DRB Application No.: 04DRB-00093 ~~(PUP)~~ <sup>FINAL</sup>  
Project Name: **SNOW HEIGHTS ADDITION**  
Agent: Surveys Southwest

**DRB CASE NO/PROJECT NO: 1003216**

**CITY OF ALBUQUERQUE  
PLANNING DEPARTMENT  
8/25/04 DRB COMMENTS**

**RE: Lot 12-C, Block 141, Snow Heights Addition/final plat**

PLAT OF
 LOT 12-C-1, BLOCK 141
 SNOW HEIGHTS ADDITION
 SECTION 8, T. 10 N., R. 4 E., N.M.P.M.
 CITY OF ALBUQUERQUE
 BERNALILLO COUNTY, NEW MEXICO
 JANUARY 2004
 SHEET 2 OF 2

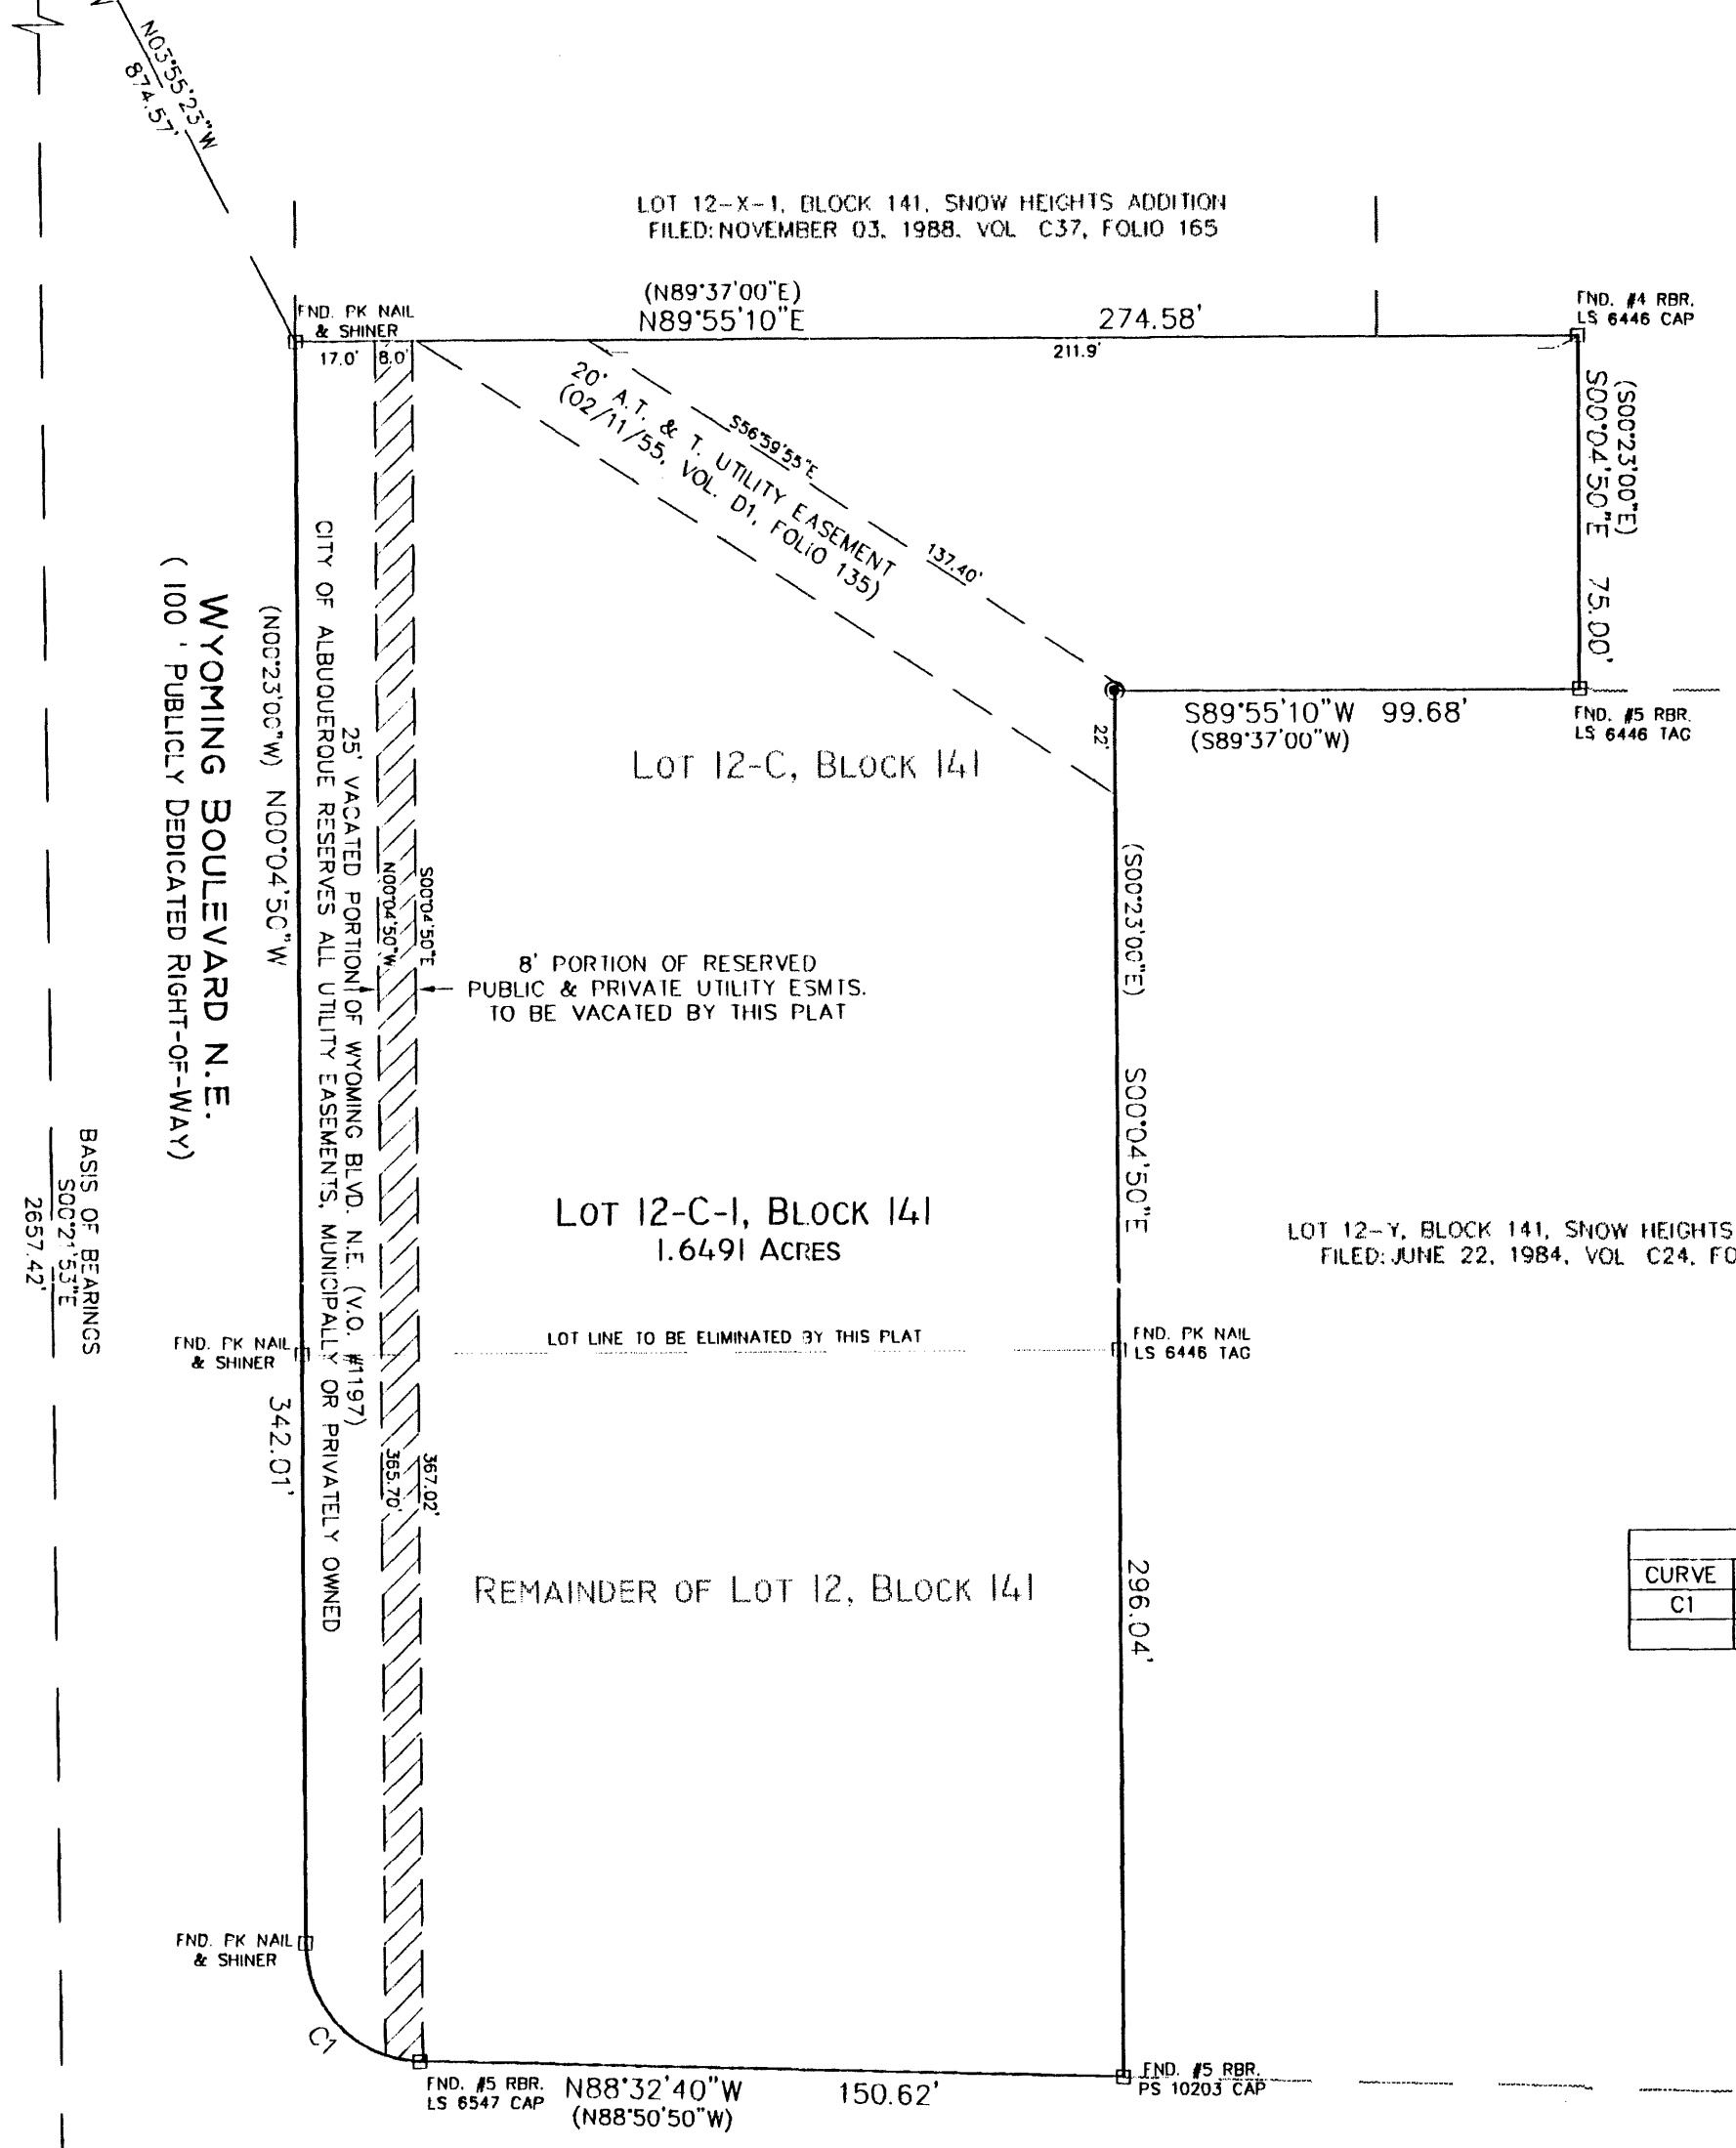
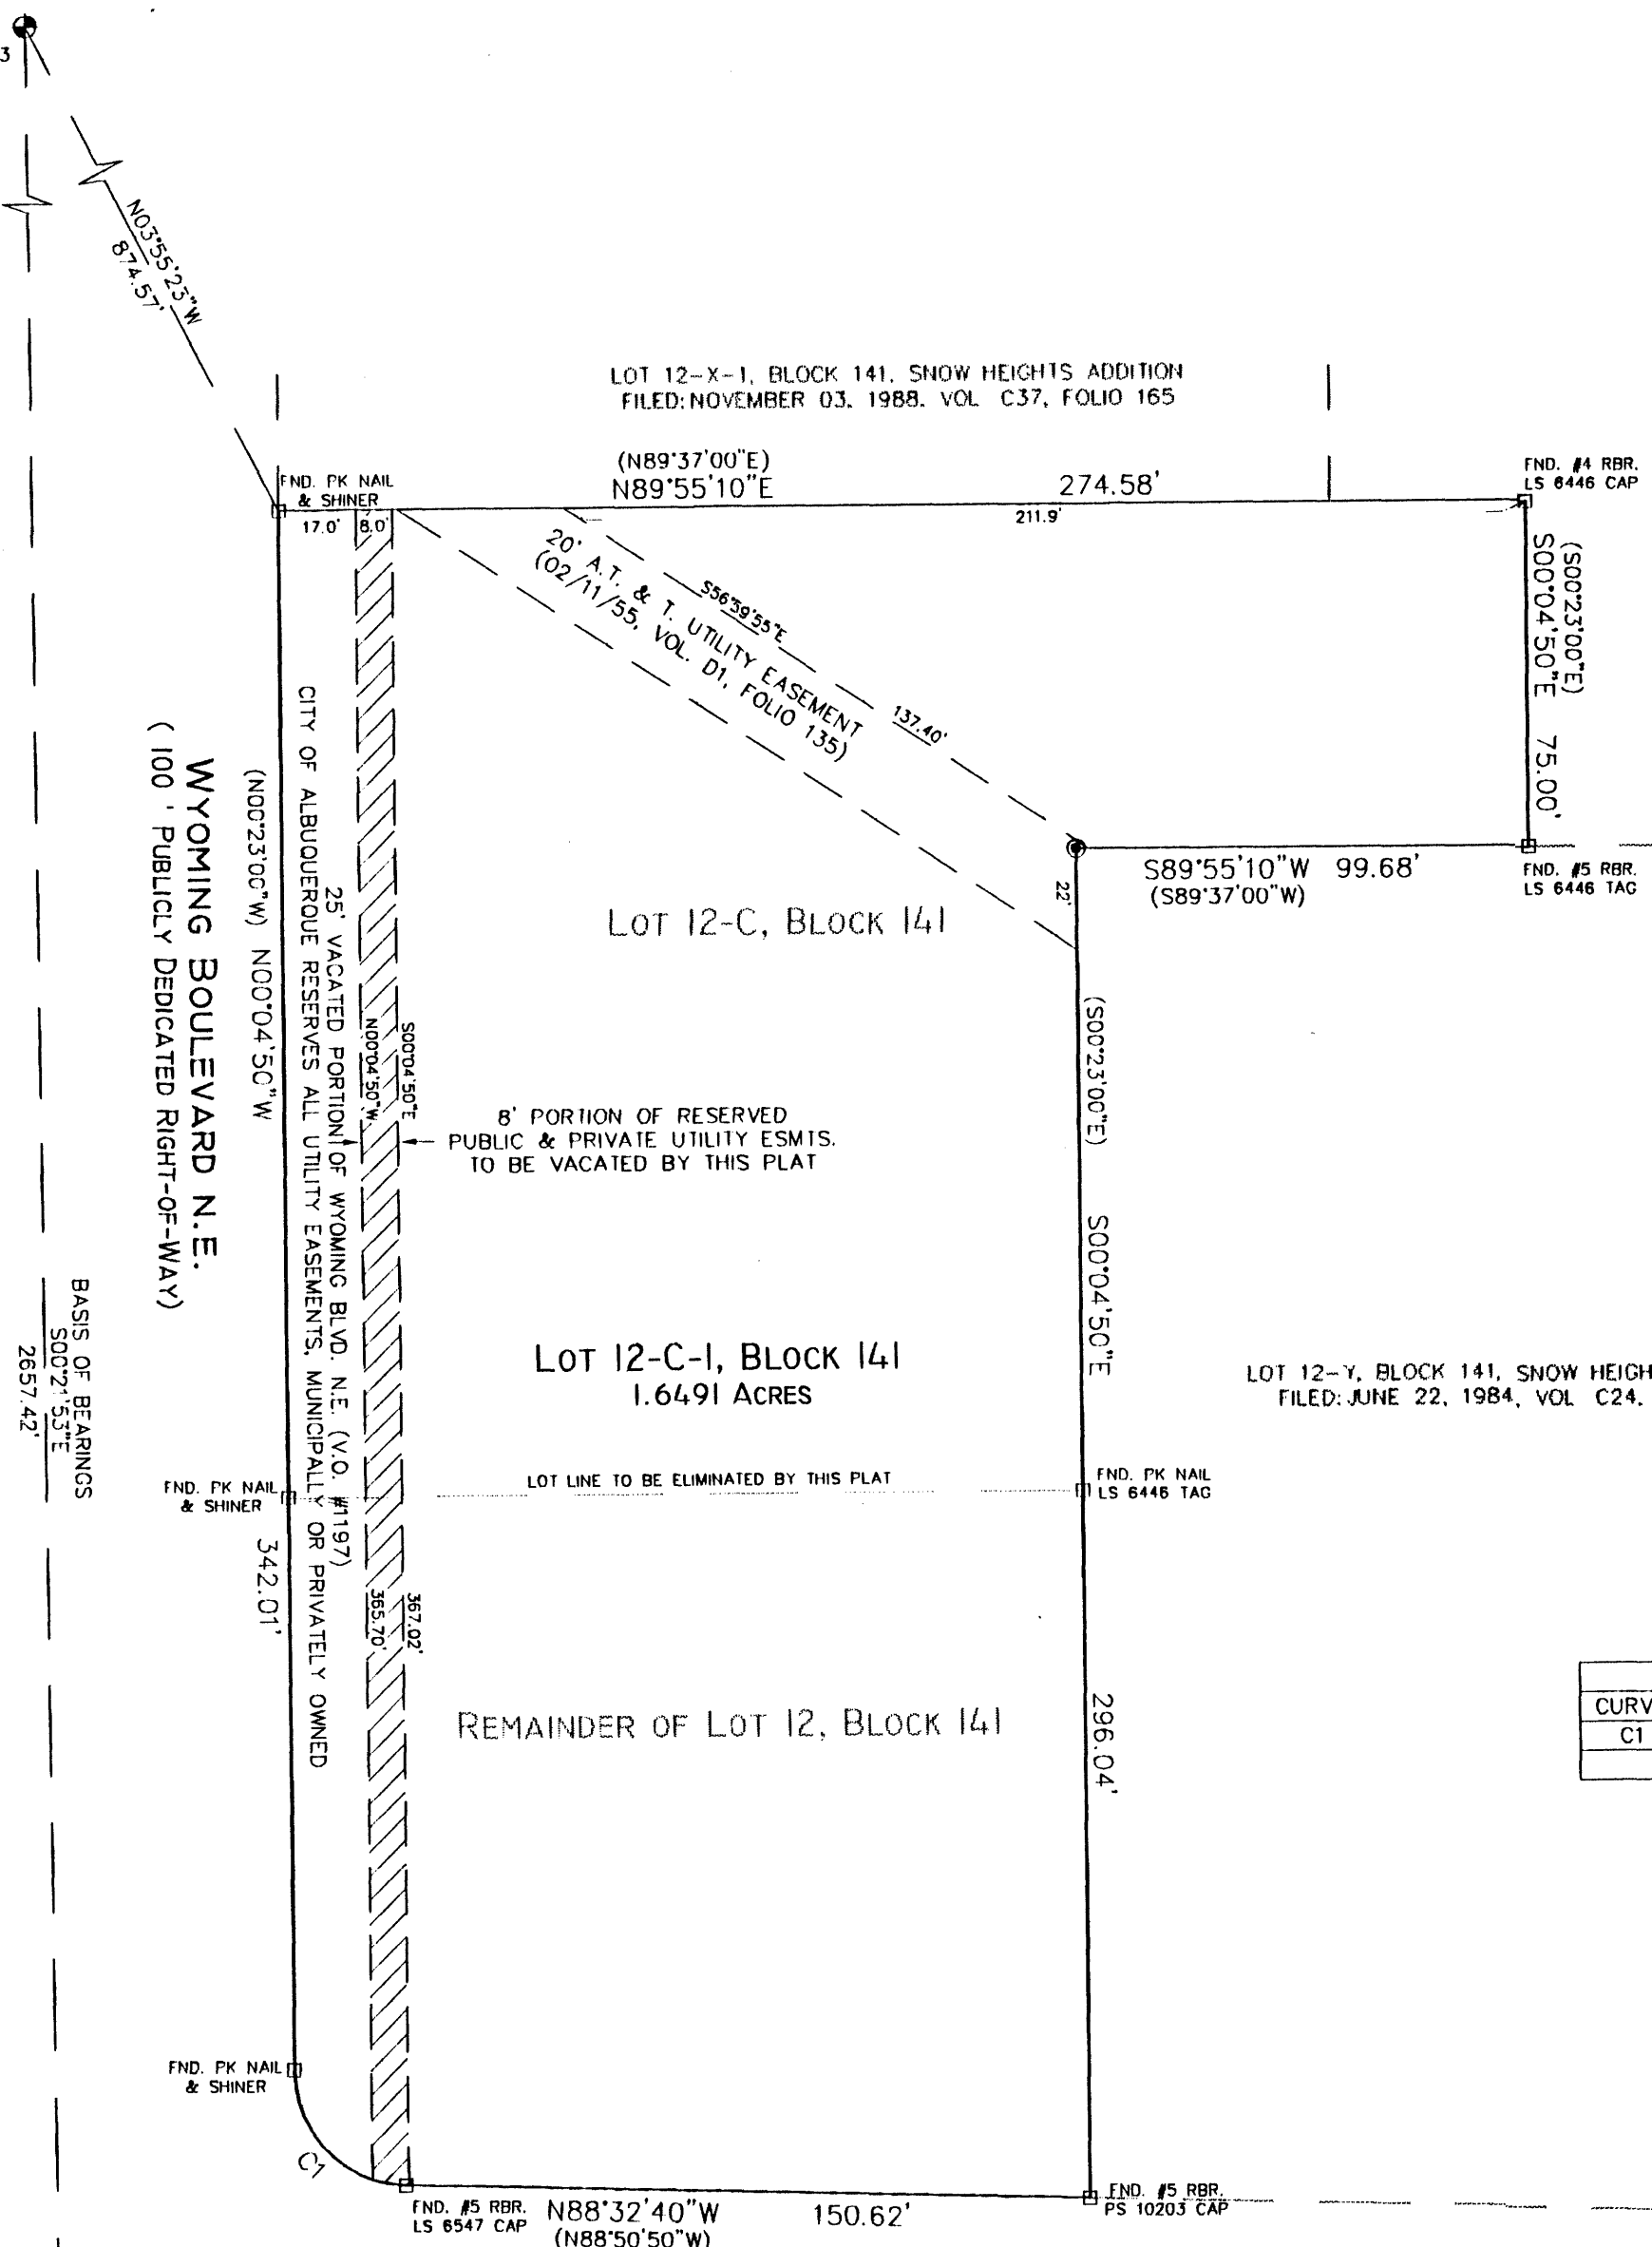
- 1) The radius for C-1 shall be modified to skirt the power pole.

1) Indian School requires bike lanes (6' dedication may be required) 2) C1 should be 35' radius. 3) Wyoming should be 124', however, easements along this stretch need to be provided to make determination if additional dedication will be required. 4) Infrastructure will be required for drive closures. 5) Defer to utilities having an interest in easement to be vacated.
